East Anglia One North (EA1N) and East Anglia Two (EA2) Offshore Wind Farms

Planning Inspectorate Reference: EA1N – EN010077, EA2 – EN010078

Deadline 5 – 3 February 2021

Comments of Suffolk County Council as Local Highways Authority

MARLESFORD MITIGATION SCHEME (A12)
PRELIMINARY DESIGN
(SHEET 1 OF 2)

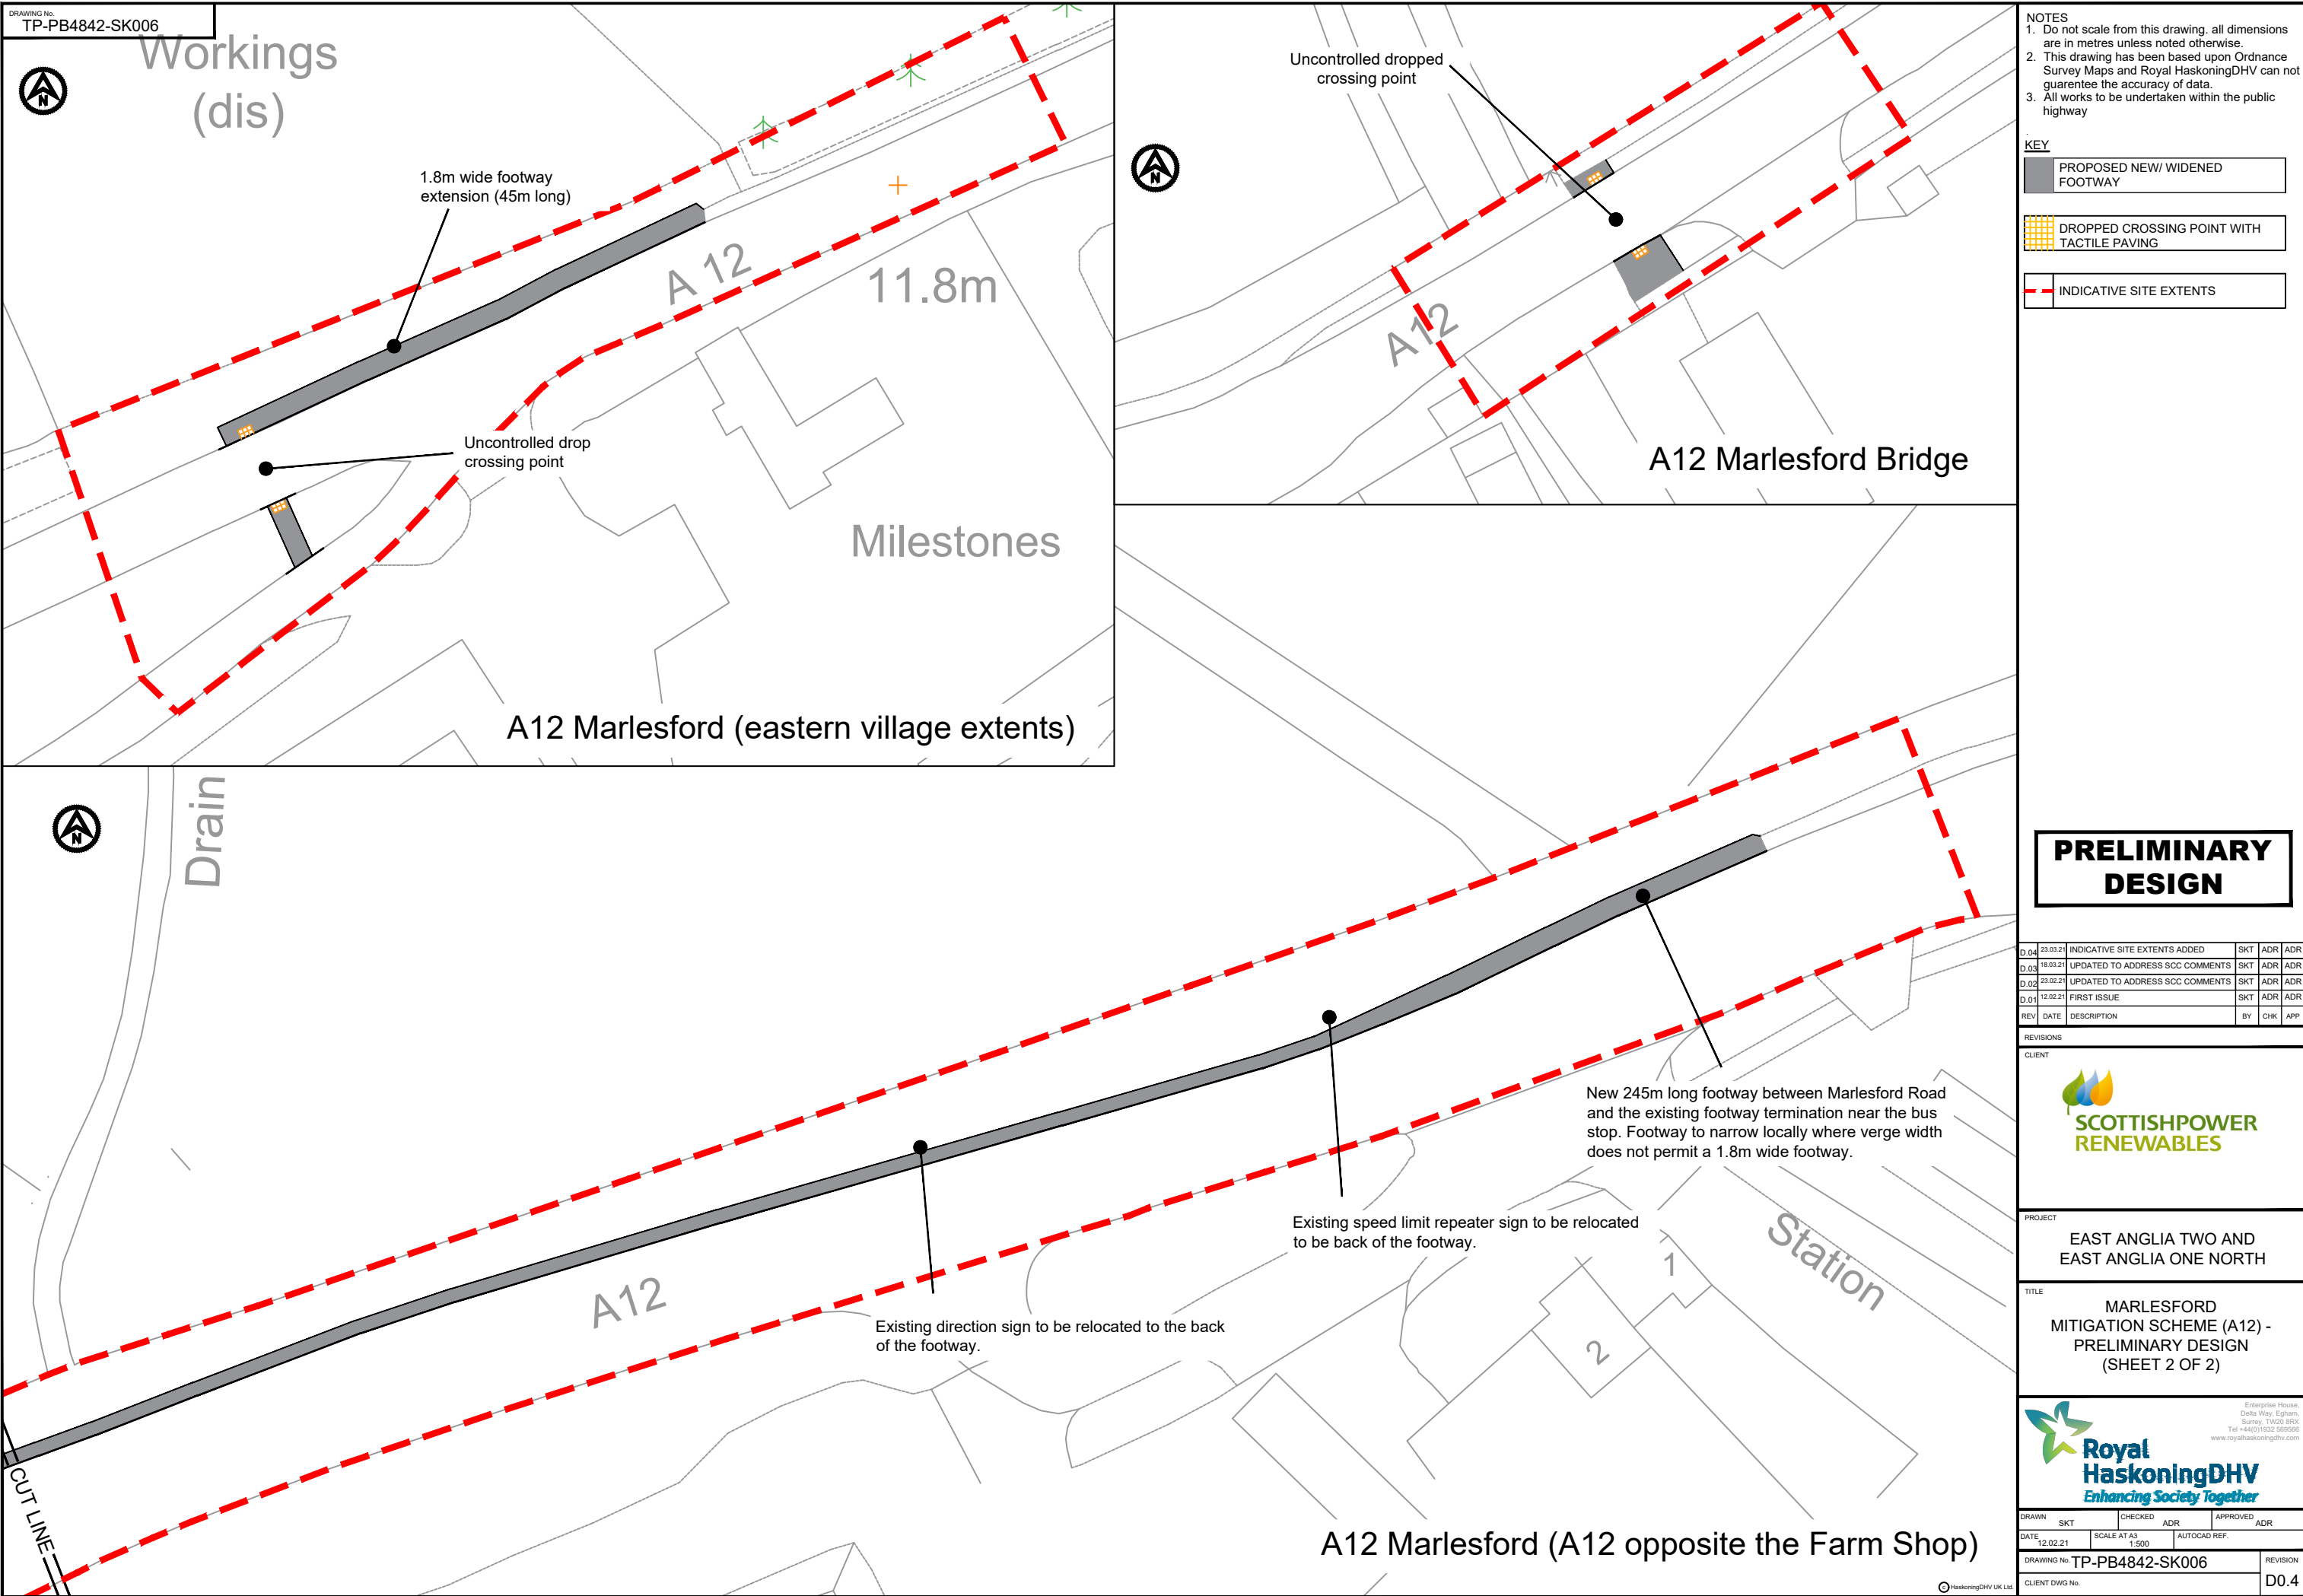
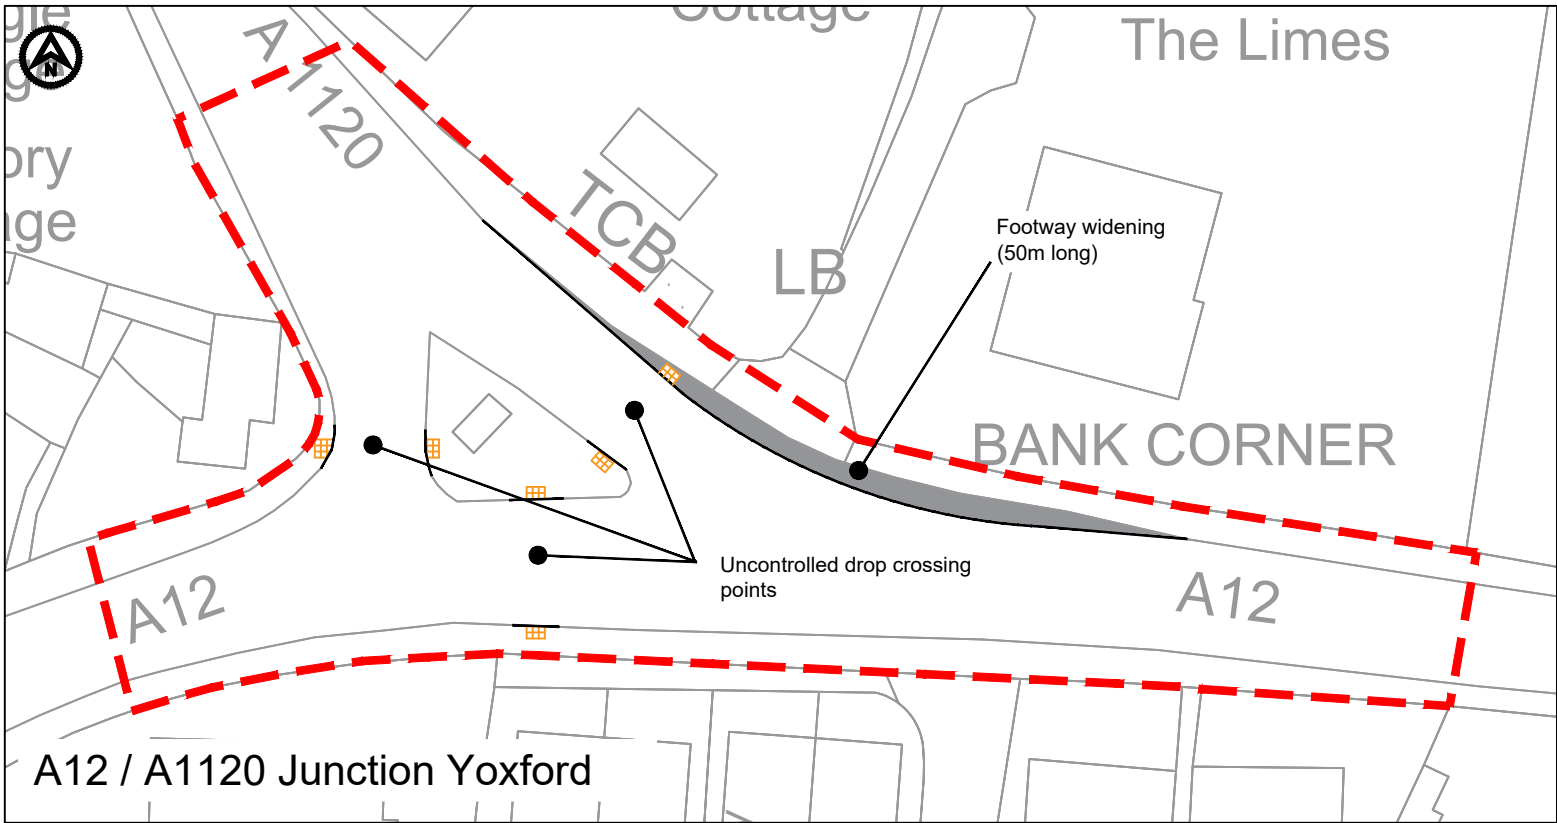
- 5.6 With regards to the Applicants' response to traffic and transport ID 7. The response fails to address SCC's concerns regarding specific impacts at the Marlesford link and the Applicants' dismissal of their impacts based on their proportional impact again which are marginally below the 30% threshold being broadly a 20% to 26% proportional increase. The Applicants' point regarding peak hour assessment for driver delay and road safety is noted and recognised with regards to peak hour modelling of junctions; however, it does imply that the hourly assessment of greatest change has not been undertaken for the categories of severance or amenity, where proportional changes may be greater than daily changes.

TITLE
YOXFORD MITIGATION SCHEME (A12) - PRELIMINARY DESIGN

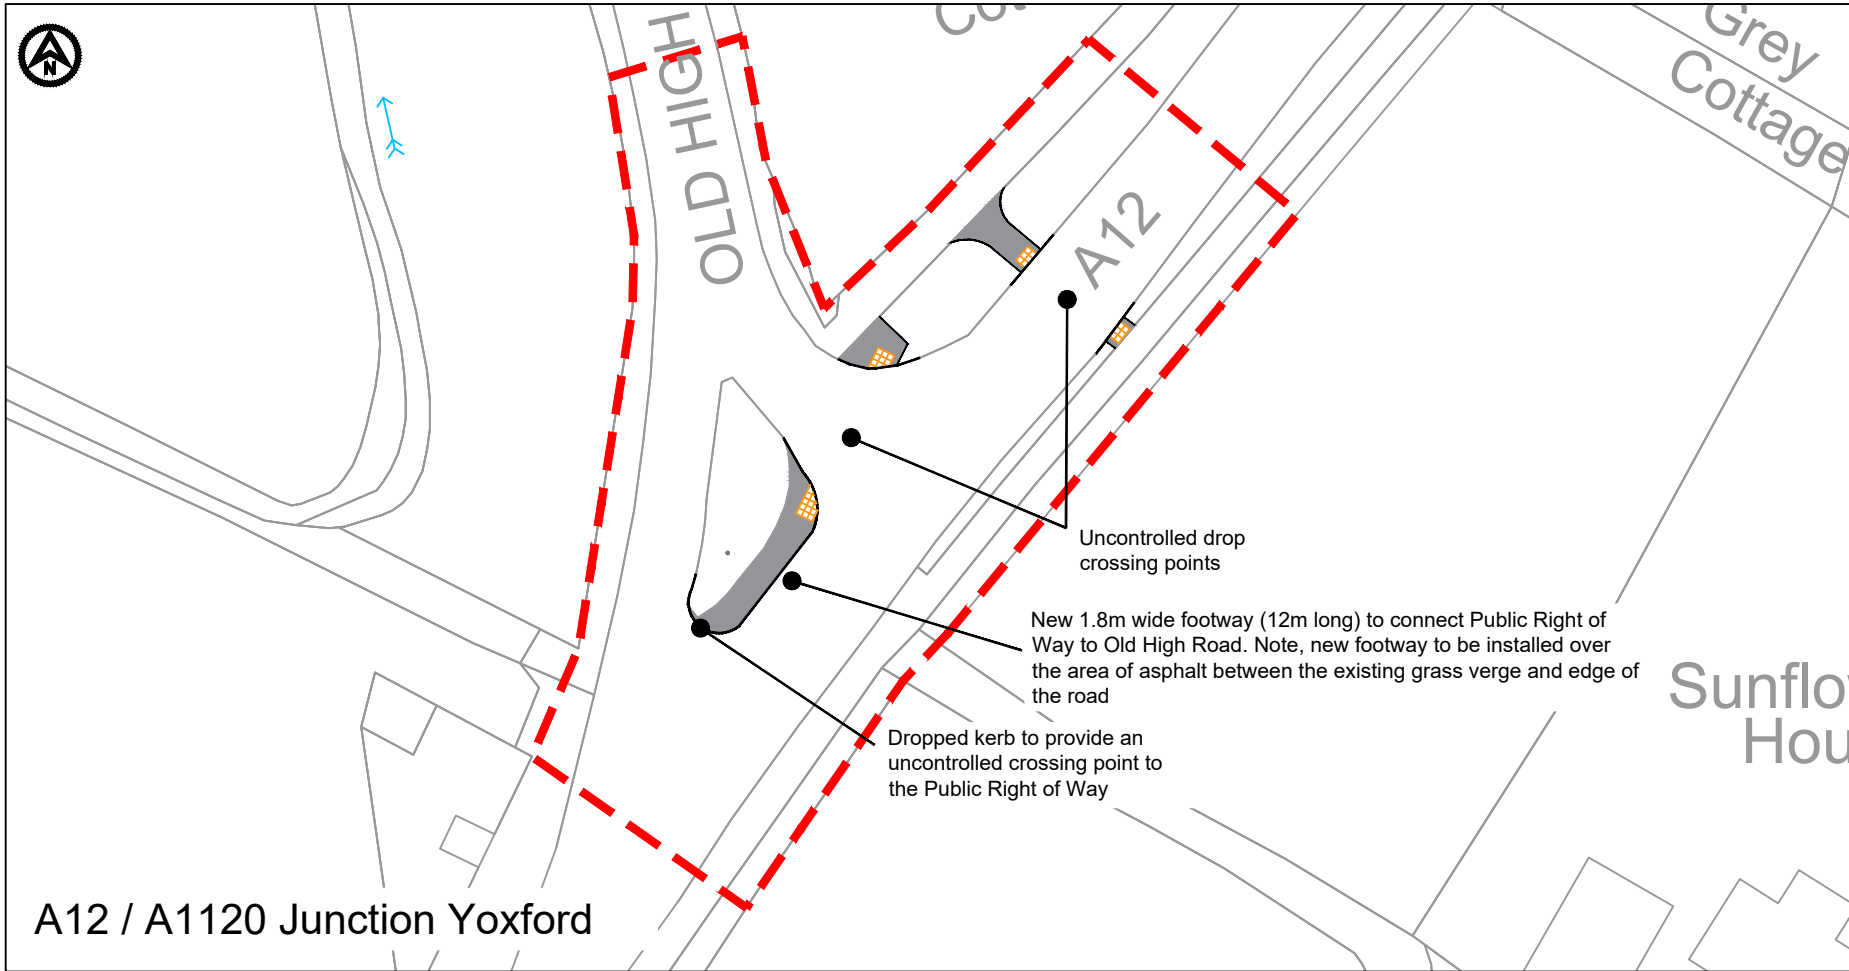
- 5.5 With regards to the Applicants' response to traffic and transport ID 6, SCC disagrees with the conclusion that a project(s) impact of a 21% or 27% increase in HGVs, which is marginally lower than the ES threshold (30% increase), should be immediately dismissed at Yoxford given that the purpose of a cumulative impact assessment is surely to understand in combination impacts across relevant projects and whether these in combination impacts trigger effects and require mitigation. The applicant has identified that they are not rigidly applying the thresholds set out within GEART; however, a slightly higher impact on these links than they have calculated would result in a 'minor' impact; and therefore, would this result in further consideration of their impacts. This appears to be rigidly applying the threshold at a sensitive location. Regardless of the threshold, SCC disagrees with dismissing impacts on this basis.
